From: [Haley Mercer](#)
To: [Jeremiah Cromie](#)
Subject: RE: LPF-21-00009 Akehurst - Request for Comment
Date: Wednesday, September 1, 2021 3:00:06 PM

We have received a final plat submittal for Akehurst (LPF-21-00009). This was given preliminary approval on 9/15/2009. Let me know if there is documentation you need to review that you are not able to find.

AKEHURST PLAT LP-08-00033
 LEVI VENN
 A PORTION OF THE NW 1/4 OF SECTION 20,
 TOWNSHIP 18 NORTH, RANGE 19 EAST, W.M.,
 KITTITAS COUNTY
 DWN BY _____ DATE _____
 D.L.P./G.W. _____ 08/2021
 JOB NO. _____ 21114
 SHEET _____ 1 OF 2
 SCALE _____ 1" = 200'

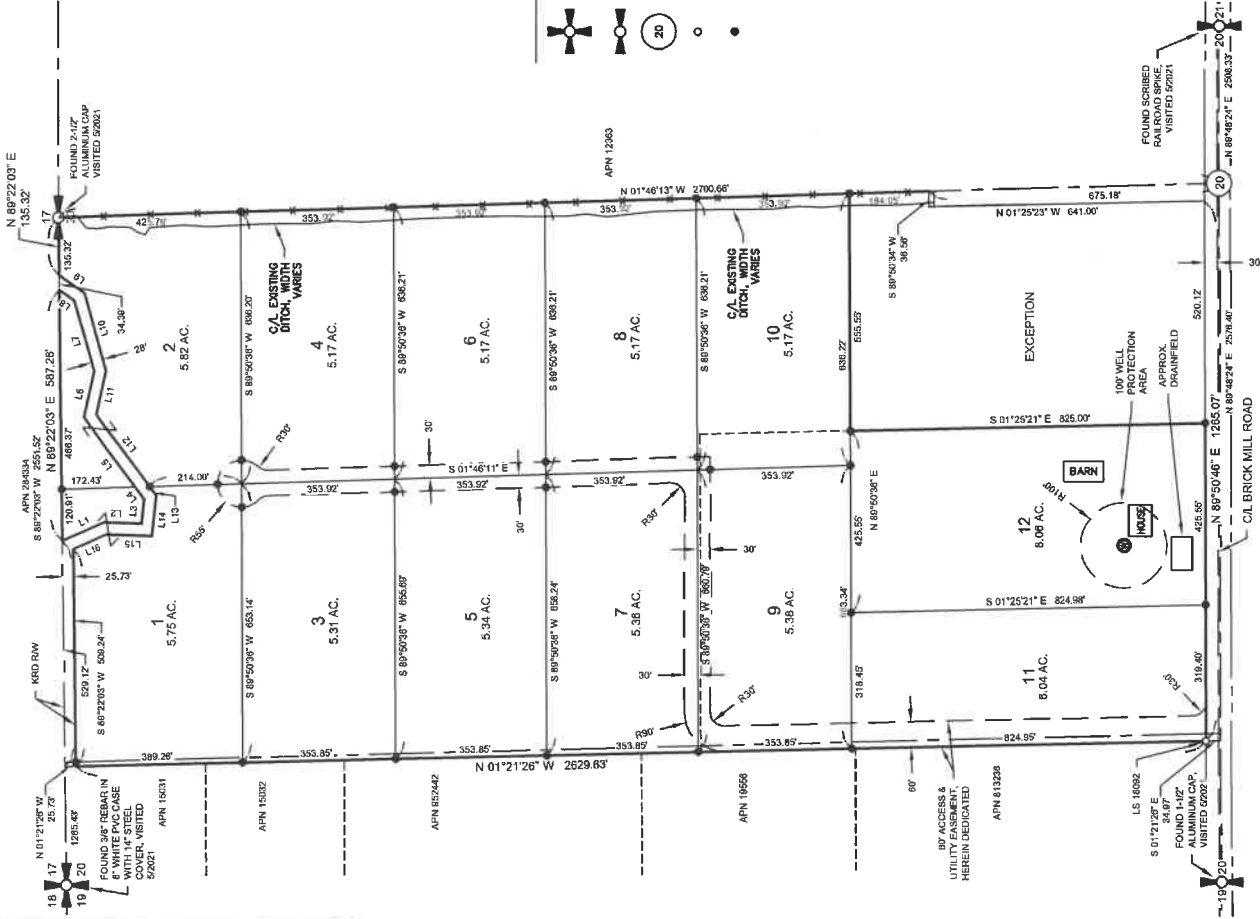
Under the Property Information area on this Plat, it is missing additional parent parcel numbers that are located within the site map. They are parcels 954945 and 954946.
